Engineers Comments Regarding Surface Water Drainage

Application Reference:	WA/43/26/DOC	Reviewer Reference:	ADC/EXT2/D2134/108
Planning Officer:	Kathryn Welch	Date of Review:	01.07.2026
Site Name:	Land West of Tye Lane Walberton		
Application Description:	Approval of details reserved by condition under WA/6/23/PL relating to conditions 12a- As Built Surface Water and 13- Prevention of Surface Water to Public Highways.		
Assessment Number:	1 of 2

Application Reference: WA/43/26/DOC Site Name: Land West of Tye Lane Walberton	Initial Issue Date: 01.07.2026 Issue Date: 01.07.2026 Reviewer Reference: ADC/EXT2/d2134/108
---	--

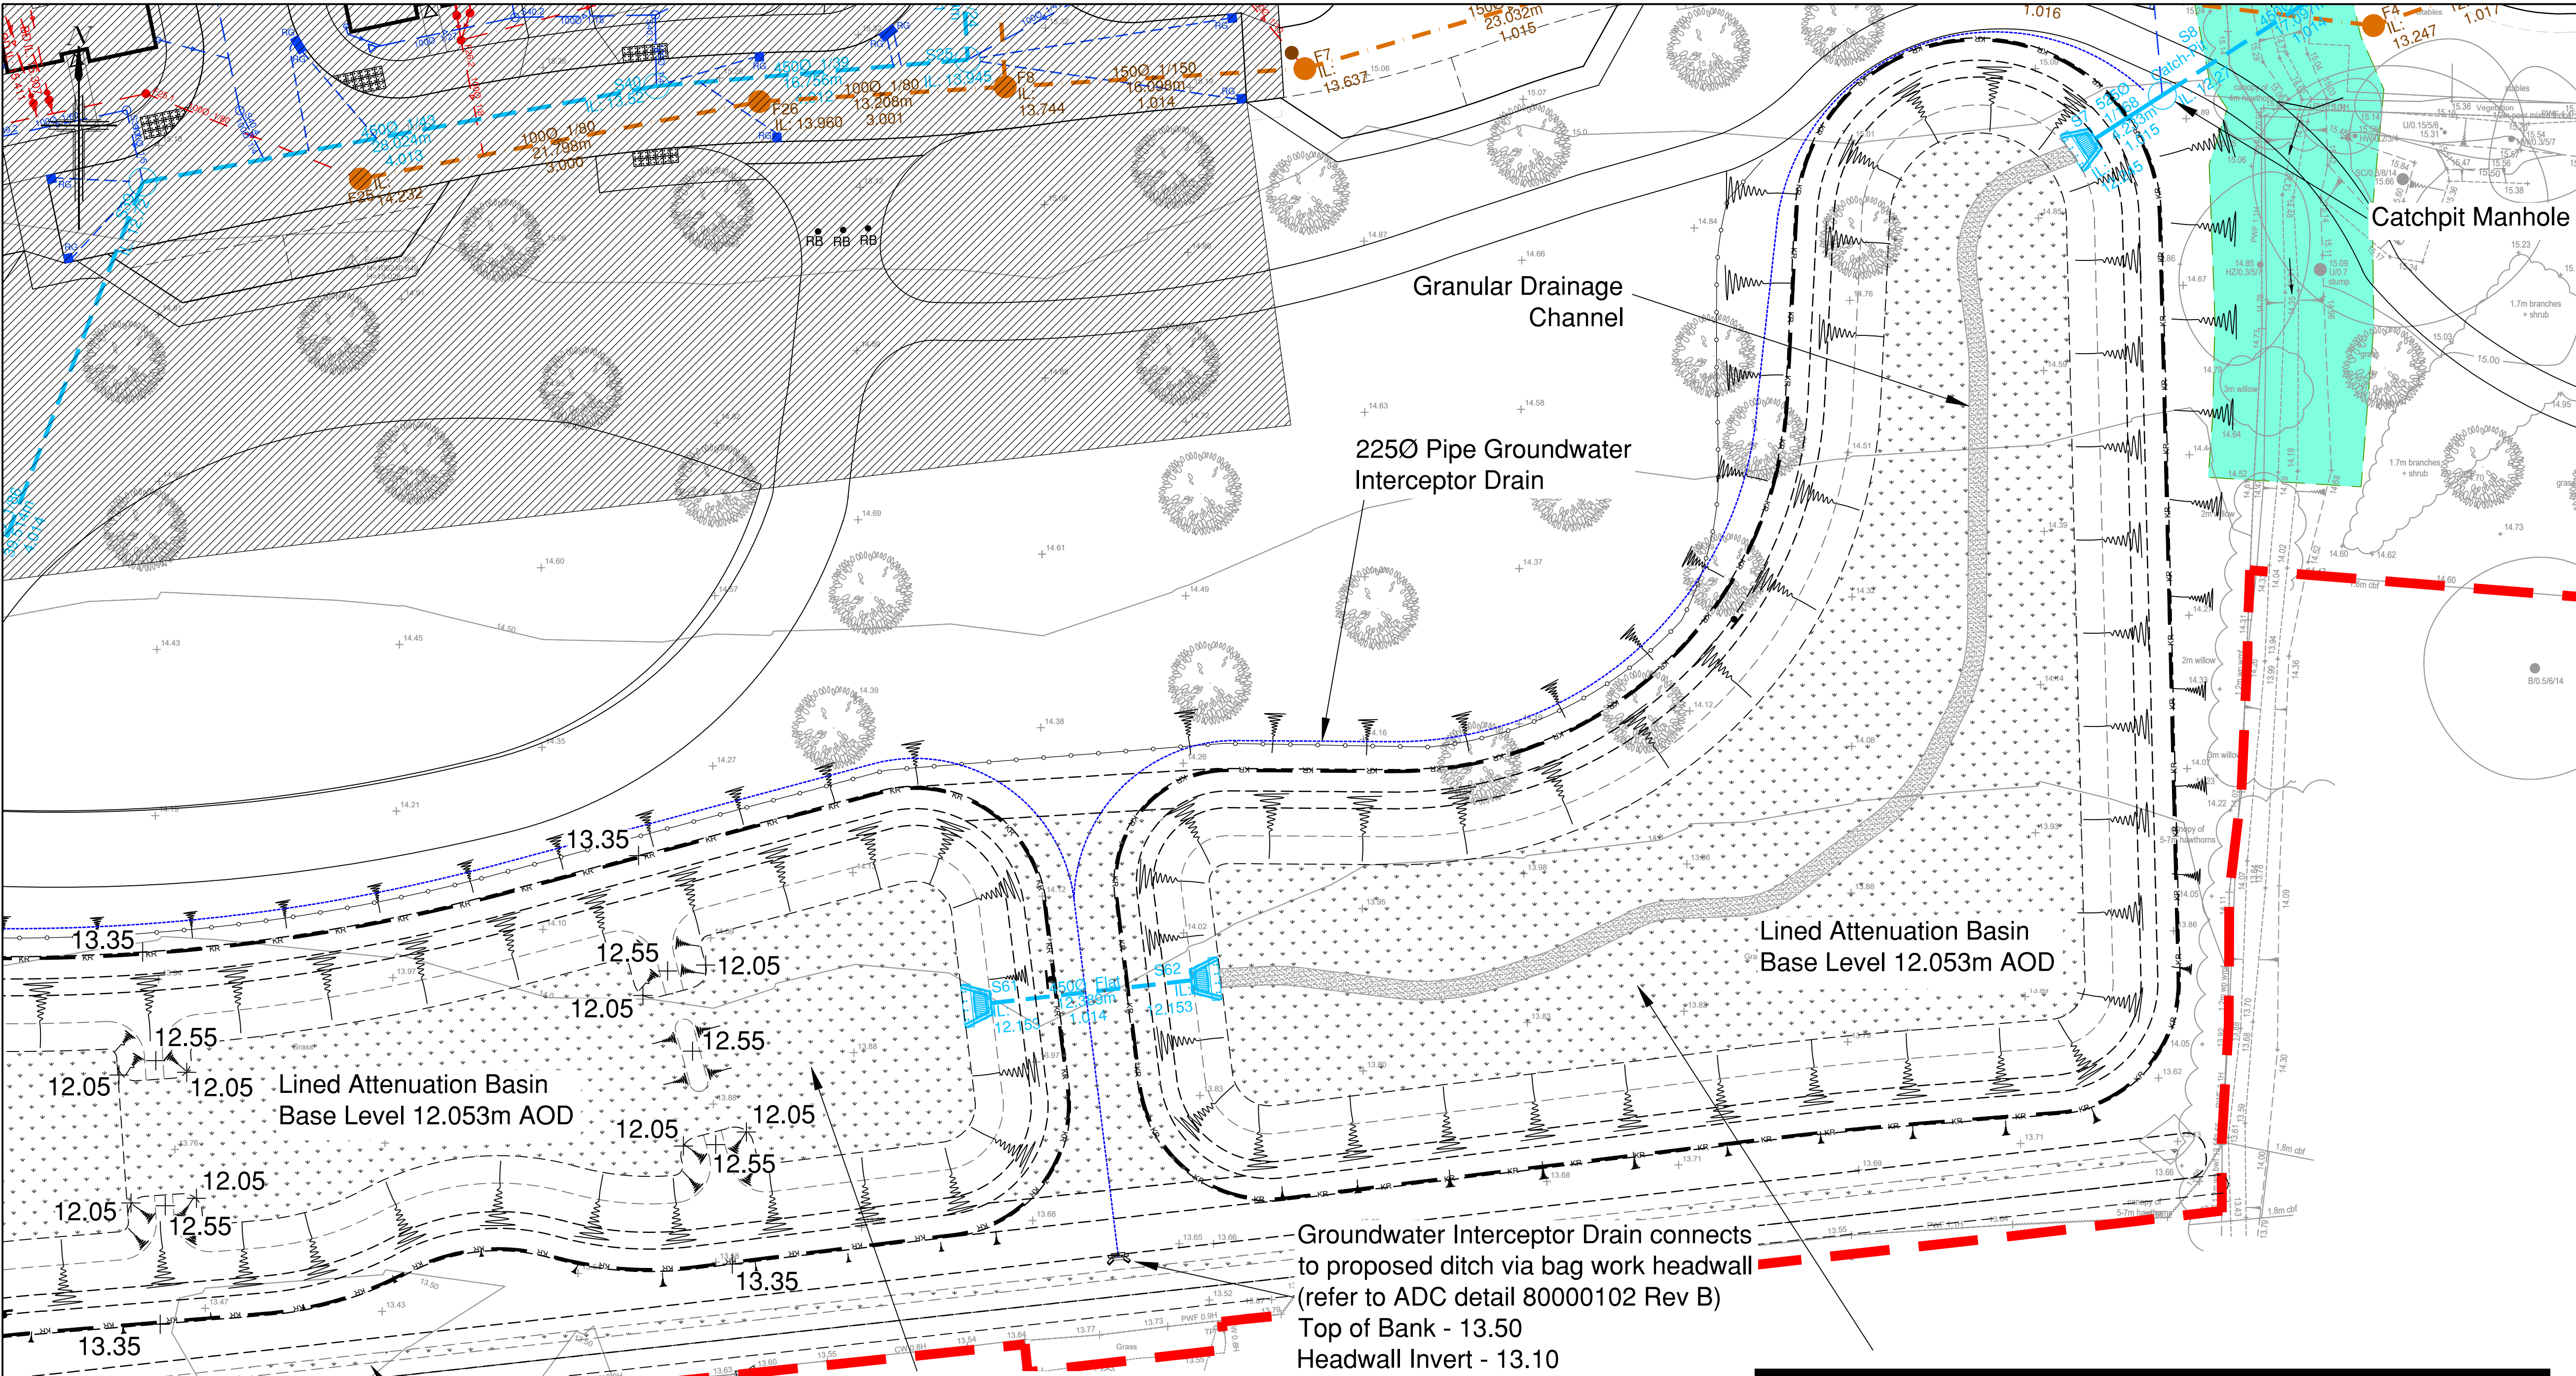
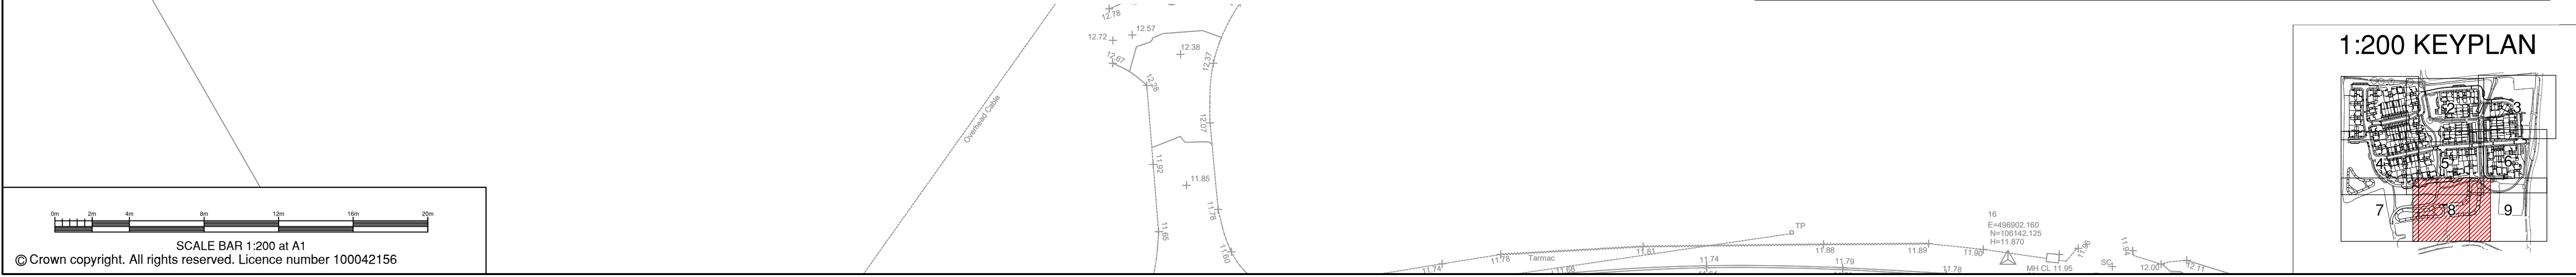
3	Section 4.2 advises the SUDS basin base levels were approx. 100-200mm shallower and banks have been raised to mitigate. Whilst the summary of 4.3 is noted, this variation dictates that 1D modelling shall be reviewed to ensure there is are no increased risks of flooding elsewhere on/off site. In addition, further evidence of the basin installation shall be provided to demonstrate the liner and flotation design was also updated and is compliant.	No response or data appears to be have been submitted to address this fundamental comment. The as-built levels indicate the volume of storage may be reduced thus there may be a risk of flood occurrences. Comment outstanding.	Drawing 470/A has been provided detailing the as-built levels overlaid to the current design, however the applicant has not provided any summary. Please note the verification report dictate the reviewer to present their assessment. Comment outstanding.
